**NEW RESTAURANT & MICRO-BREWERY, OVERSEAS PASSENGER TERMINAL
(TENANCY 5), CIRCULAR QUAY WAY, THE ROCKS, SYDNEY (SSD 7683) –
RESPONSE TO SUBMISSIONS**

As a delegate of the Heritage Council of NSW, I provide the following comments.

1 Brew-pod Elevation
Scale 1:50

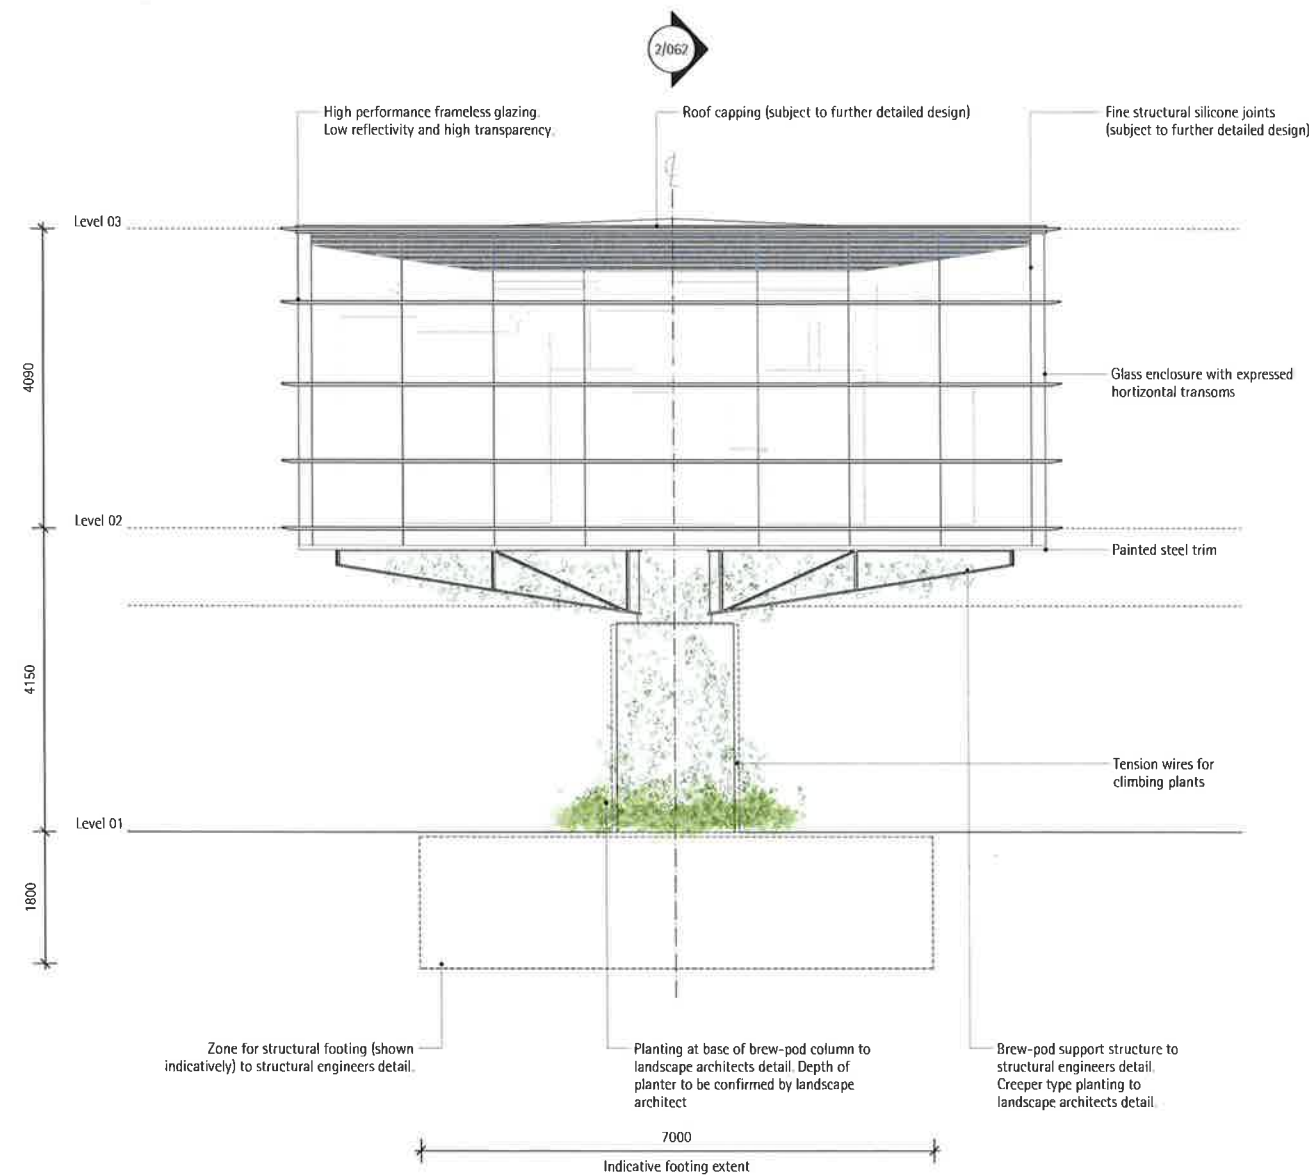
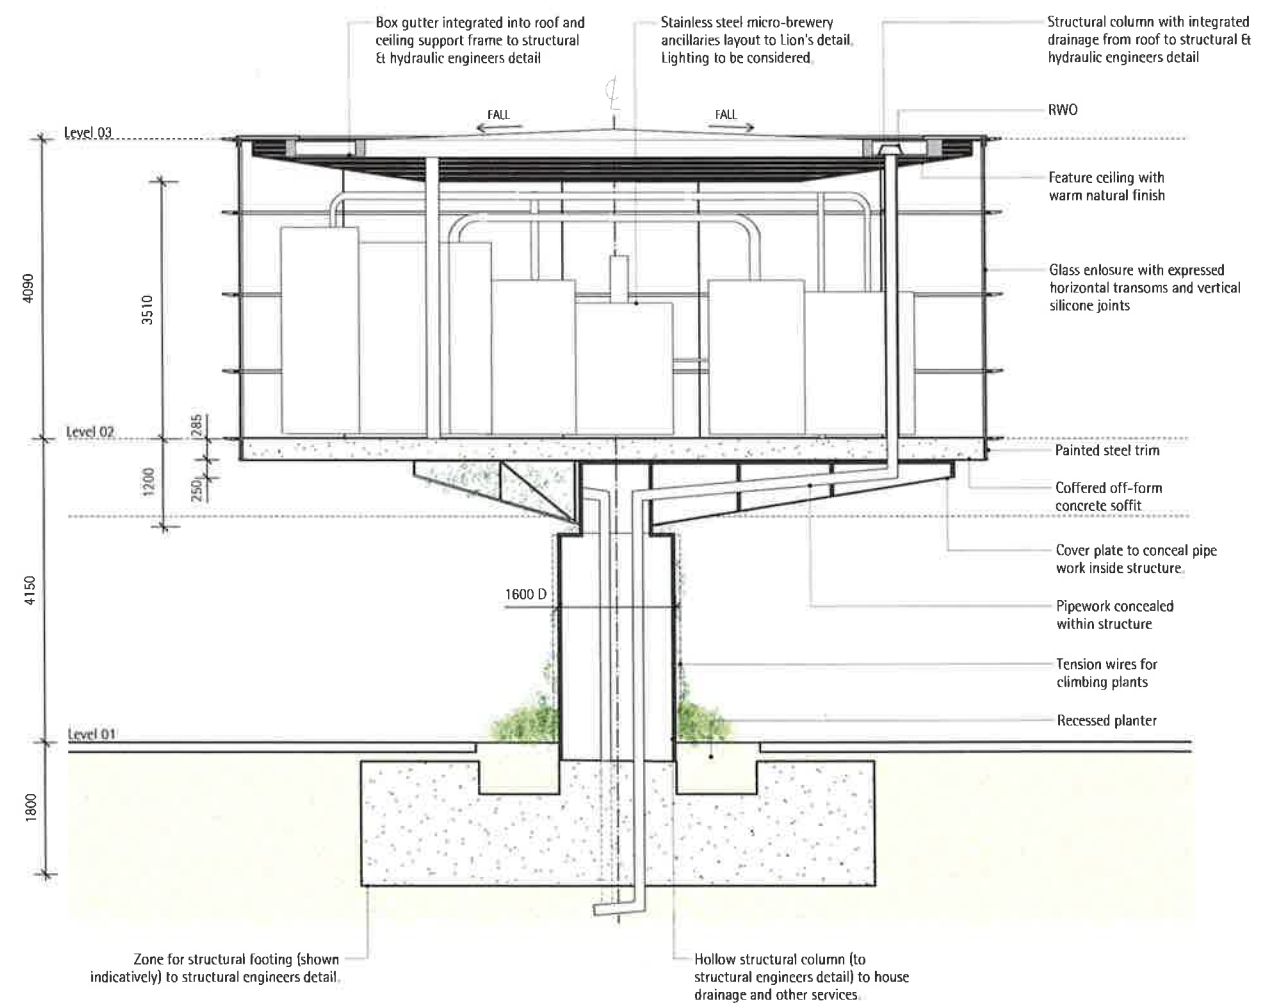
- It is understood that the proposal has been revised to relocate the external micro-brewery structure closer to the OPT. The original design positioned the external element in a location that had adverse visual impacts on the Sydney Opera House and the Campbells Stores' setting. The revised proposal relocates the structure south towards the OPT which reduces the visual impact on the setting and on the significant views to the Sydney Opera House.

The revised design reduces the structure's height from 8.24m to 5.2m, further reducing its visual impact. Therefore, the revised micro-brewery design is considered acceptable. Whilst it is still considered that a better option would be to locate the micro-brewery wholly within the existing building envelope, the revised design gives appropriate consideration to the retention and recovery of views and vistas to the Sydney Opera House.

- The proposed structure will be in close proximity to the approved awning for outdoor seating at Campbell's store and will be within its setting. It is therefore, recommended that the design and implementation of the new brewery structure be of high quality. Care should also be taken to avoid the new structure becoming a dominant element within the setting of Campbell's store.

- The proposed works are located within an area of mixed archaeological potential; high on the western portion of the study area, but low on the eastern portion of the study area. Archaeological information would be related to the sea walls built in this area in 1840s and the 1870s/1880s. It is noted that impacts would be confined to the piling and pad footings for the micro-brewery as no other excavation is proposed.

The archaeological assessment recommended a program of archaeological test excavation in the areas of the footings and piling locations (wherever the micro-brewery structure is located) and if archaeological information is uncovered, protection of the 1840s sea wall and detailed recording of the removal of any later sea walls and associated historic reclaimed fills.

- 2) If the proposal is approved in its current form, archaeological test excavation should occur prior to the commencement of footing and piling works for the micro-brewery.
- 3) The testing shall be guided by an appropriate research design, excavation methodology and be directed by a suitably qualified and experienced excavation director who fulfils the Heritage Council's Excavation Director Criteria for the excavation of state significant archaeological sites.
- 4) The testing results shall guide the next stage of development. Areas of state significant archaeology and substantially intact archaeological evidence shall be appropriately managed and avoided wherever possible in the design.
- 5) In the event this is not possible in whole or in part, detailed full archaeological salvage shall be undertaken. This shall be guided by an appropriate research design,
